**RE: Response Letter Regarding
COM Comments for the
Stratmoor Hills Water District CSU Interconnection Modifications Project**

This letter is being provided with submittal of the revised Letter of Intent, Site Plan, and Construction Drawings for the Stratmoor Hills Water District CSU Interconnection Modifications project. The comments received by the review agencies are outlined below, along with responses regarding requested information.

Site Plan

PROJECT NO: 04-22-0209  
 SHEET NO: C-01  
 DATE: MAR 2024  
 PAGE NO: - OF -

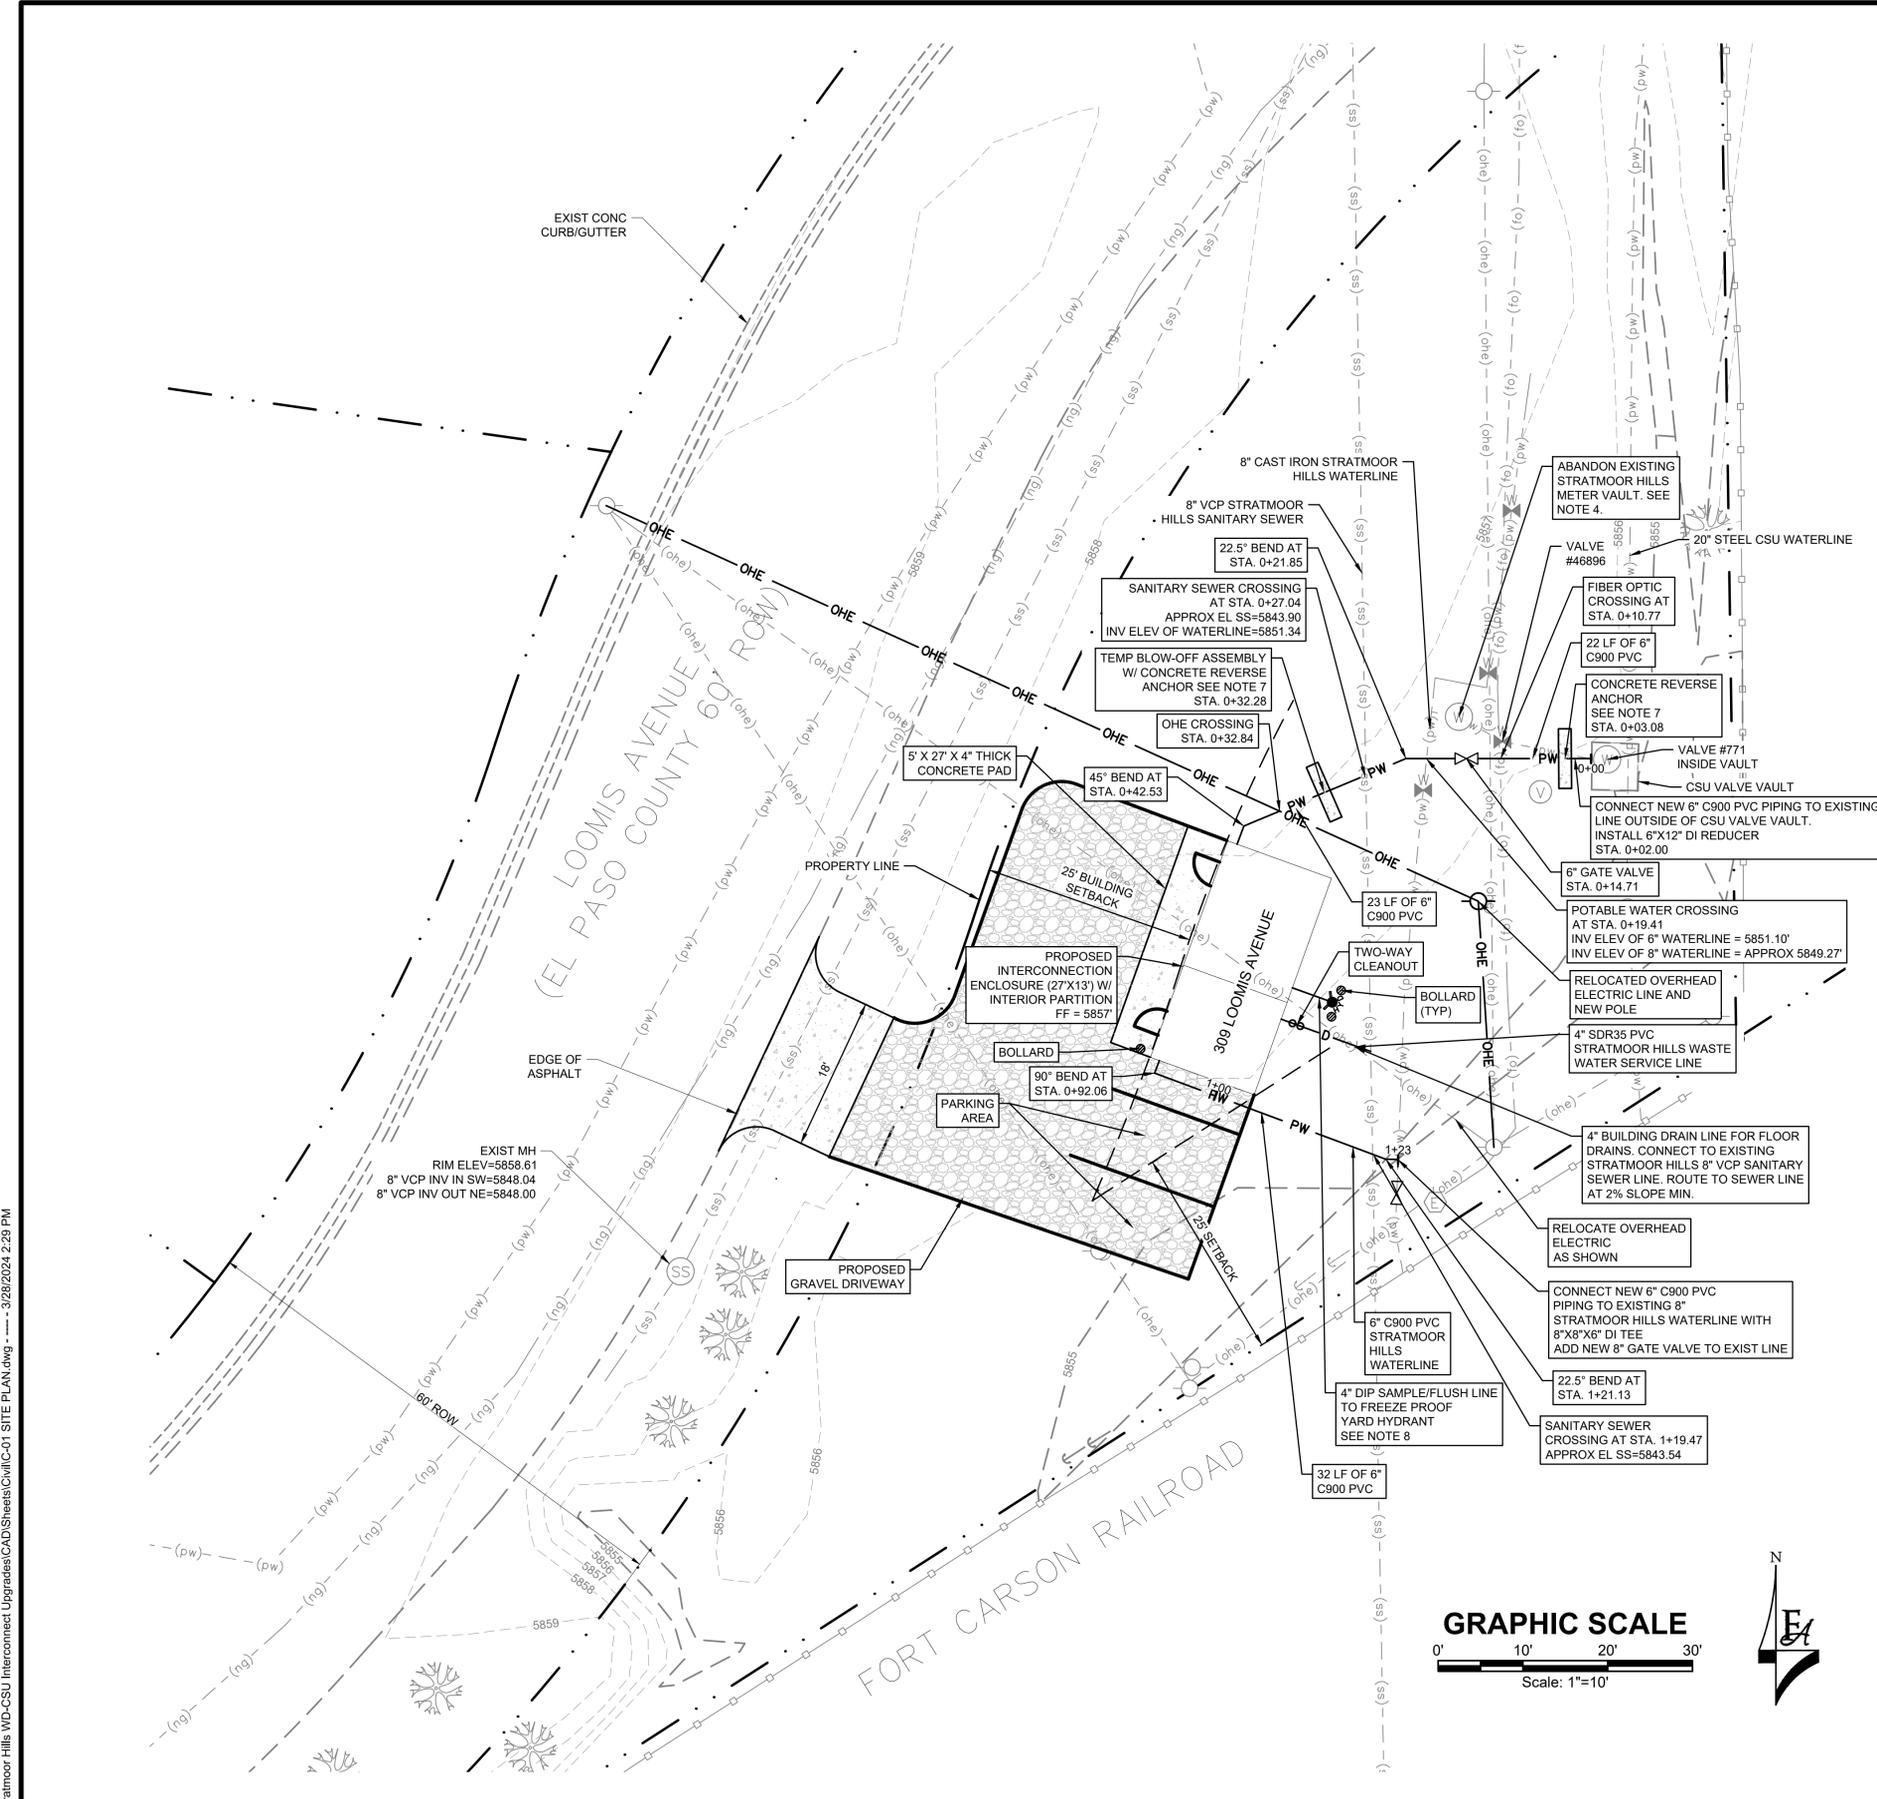
"Hi Claire, I'm reaching out to discuss an additional comment on COM2323 Stratmoor Hills Water District-CSU Interconnection COM. The county's engineering criteria requires a 5' attached sidewalk alongside Urban-Local roadways. The site is adjacent to an urban local roadway therefore sidewalk along the site's frontage to the road will be required. In the next submittal we will need construction drawings prepared by a professional engineer licensed in the state of Colorado. The construction drawings should include the sidewalk alongside the frontage of the road and El Paso County's standard

construction notes. A Financial Assurance Estimate form will be required as well. Our criteria for sidewalks can be found in ECM Chapter 2 and Chapter 6. The driveway shown on the site plan should have a callout for El Paso County Standard Detail Drawing SD_2-24. Joe can open a slot for the financial assurance estimate form and construction drawings on EDARP.”

The County approved an exemption for the sidewalk requirement and therefore is not shown on the revised site plan.

PROJECT NO: **04-22-0209**
SHEET NO: **C-01**
DATE: NOV. 2023
PAGE NO: 3 OF 13

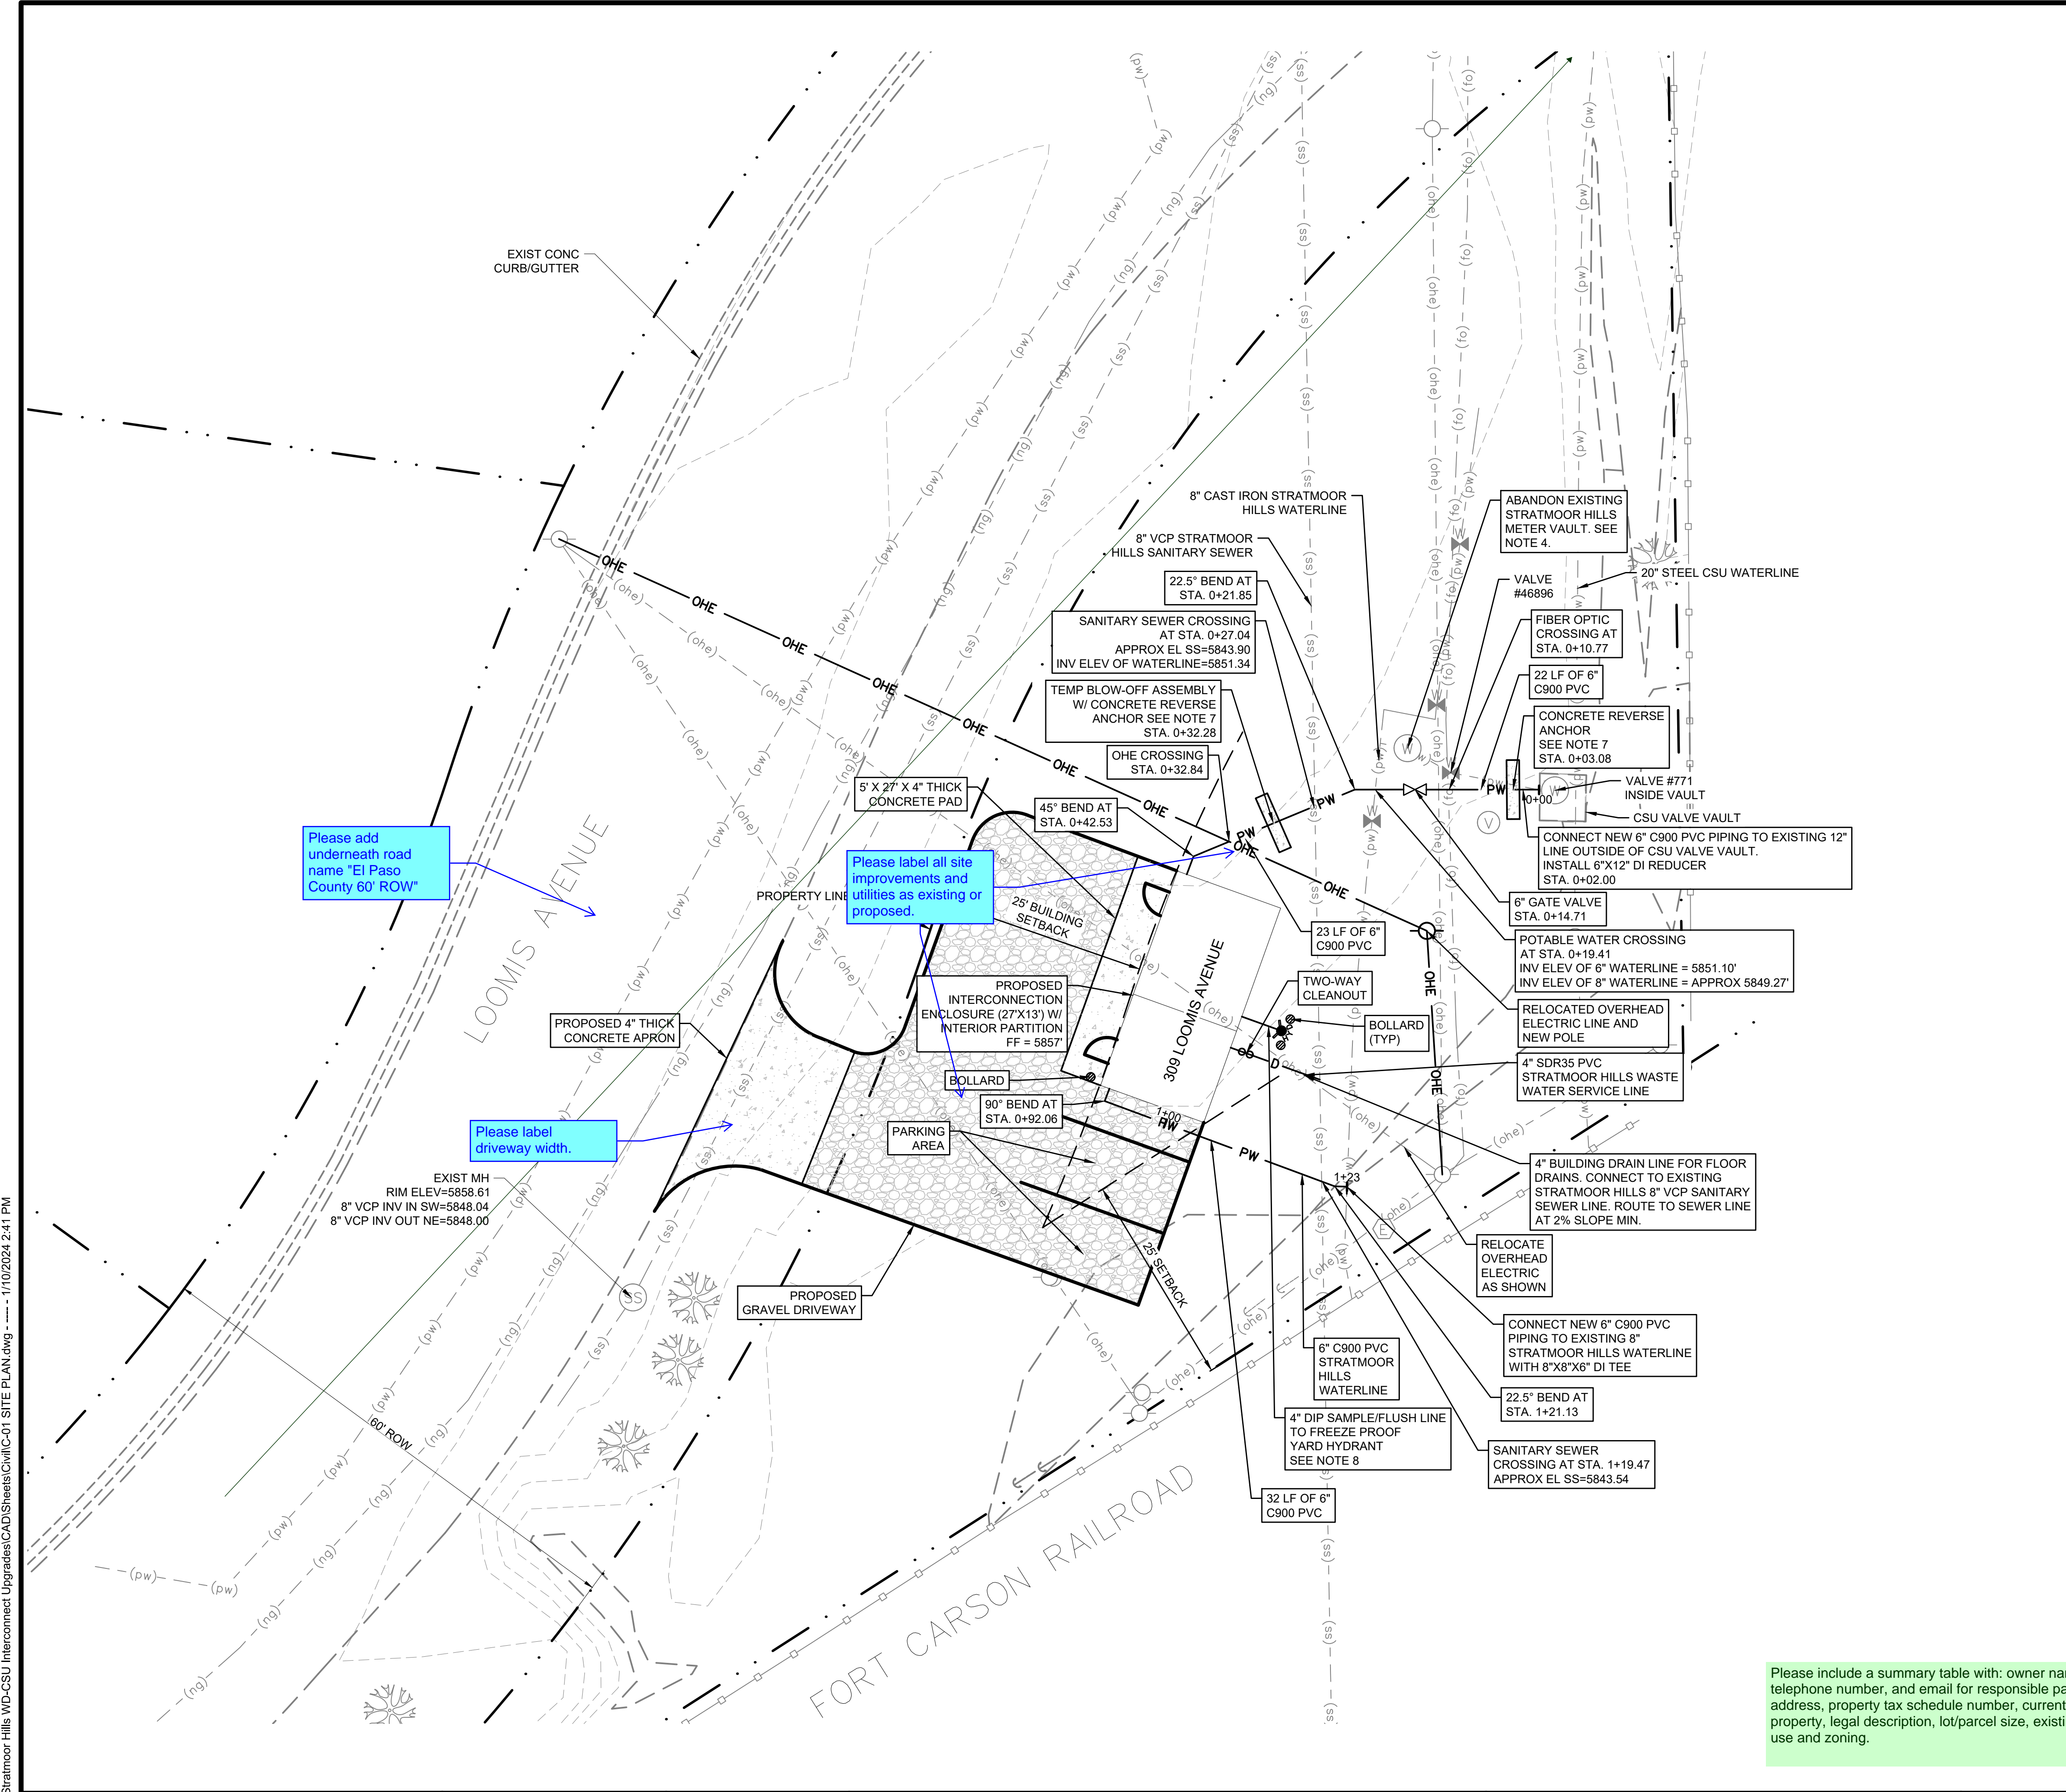
Please add underneath road name "El Paso County 60' ROW"

Please label all site improvements and utilities as existing or proposed.

Please label driveway width.

Please remove

This has been added to the revised Site Plan.

A note has been added to the Site Plan that specifies that all un-boxed callouts and shaded lines are existing and all boxed callouts and bold lines are proposed.

This has been added to the revised Site Plan.

This has been removed from the revised Site Plan.
